February 7, 2022

Re.: Geddes Marina Remediation Shoreline Substantive Development Permit,
PA22-001, First technical review comments

**PARCEL MAP**

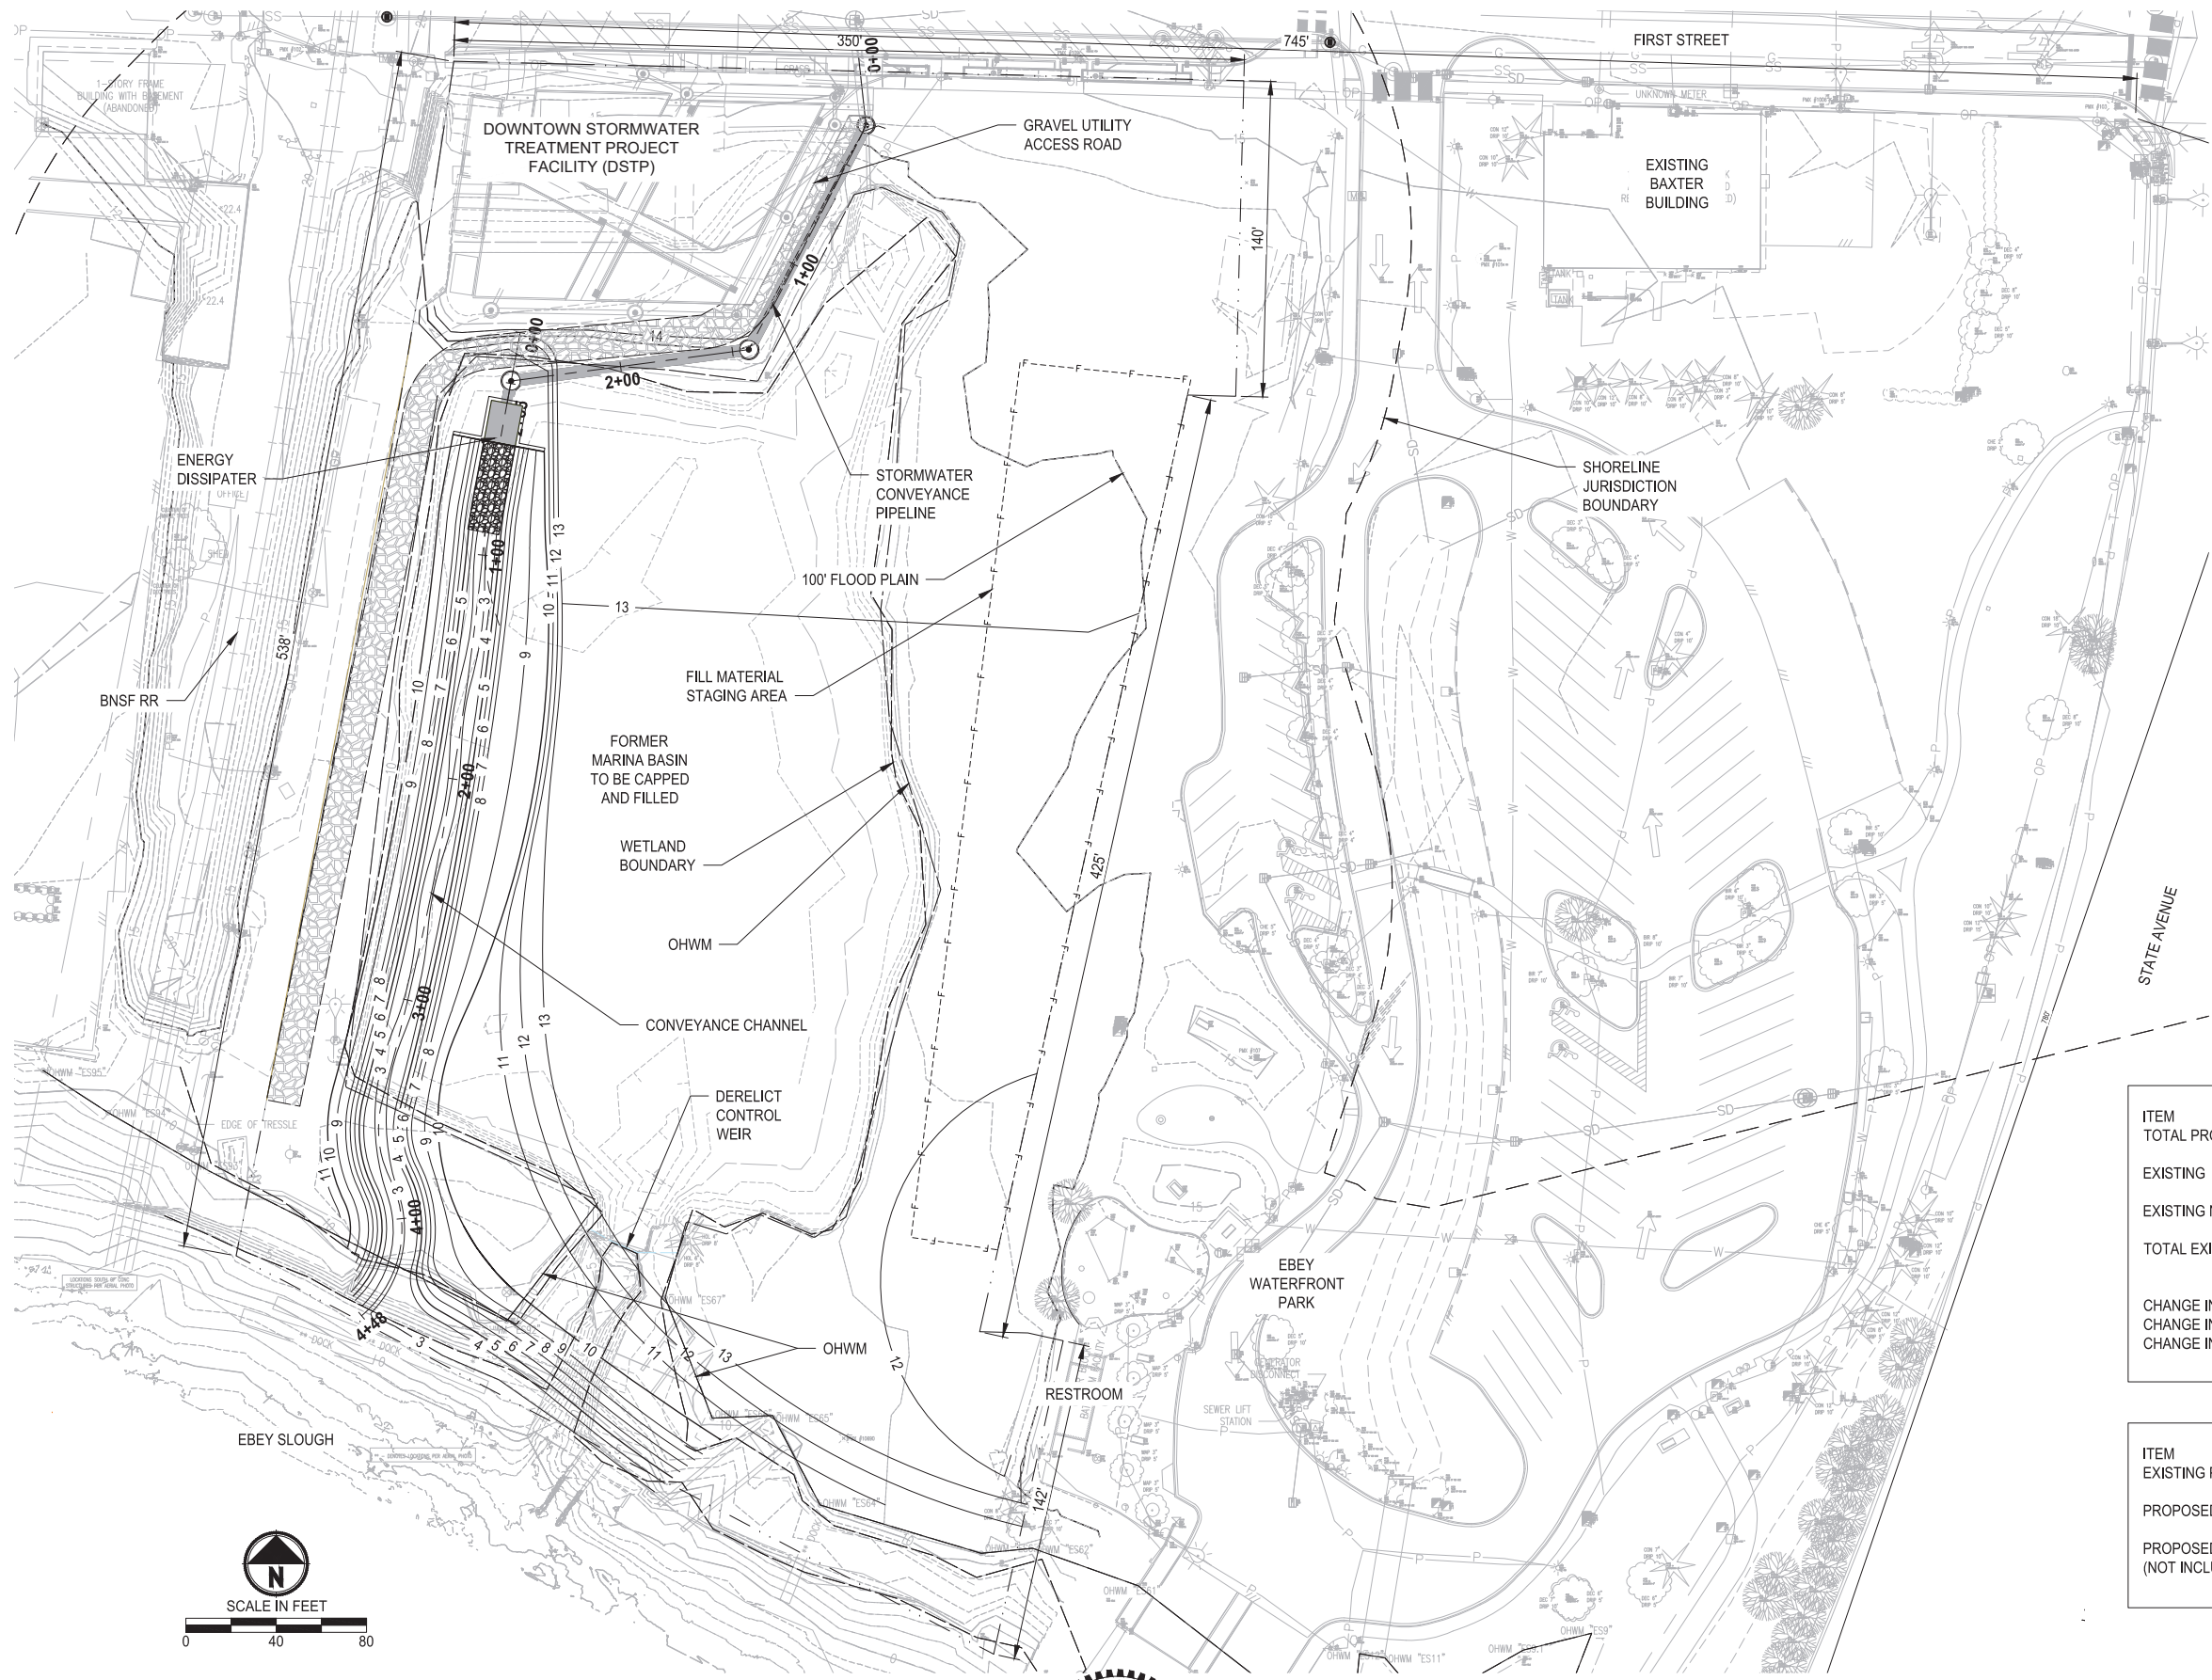
- 5) The Plan Set, Sheet G3 Parcel Map – please correct the parcel ID numbers for 30053300202500 and 3053300202900, and add the easements identified in Schedule B of the Title Report.

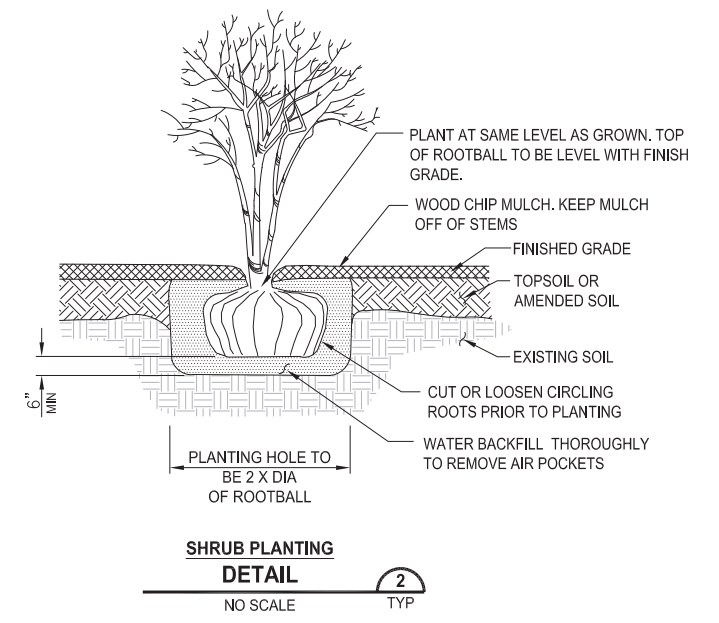
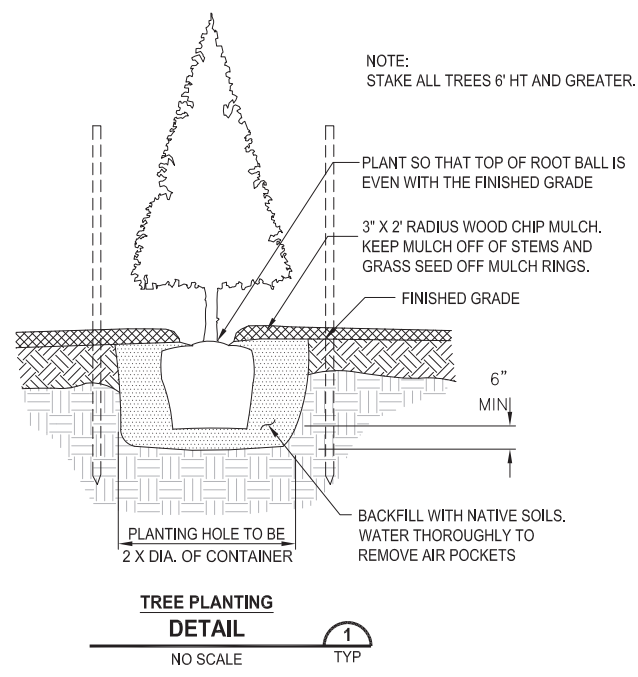
- d. Provide more details of the proposed on-site restoration for compliance with MMC 22E.010.140(1) Preliminary Plan. The critical Areas mitigation plan should include or reference Sheet LS1 Landscape Restoration Plan. There may duplication with the report; however, the preliminary mitigation plan needs to address [MMC 22E.010.140](#) (1)(a) – (1)(d).
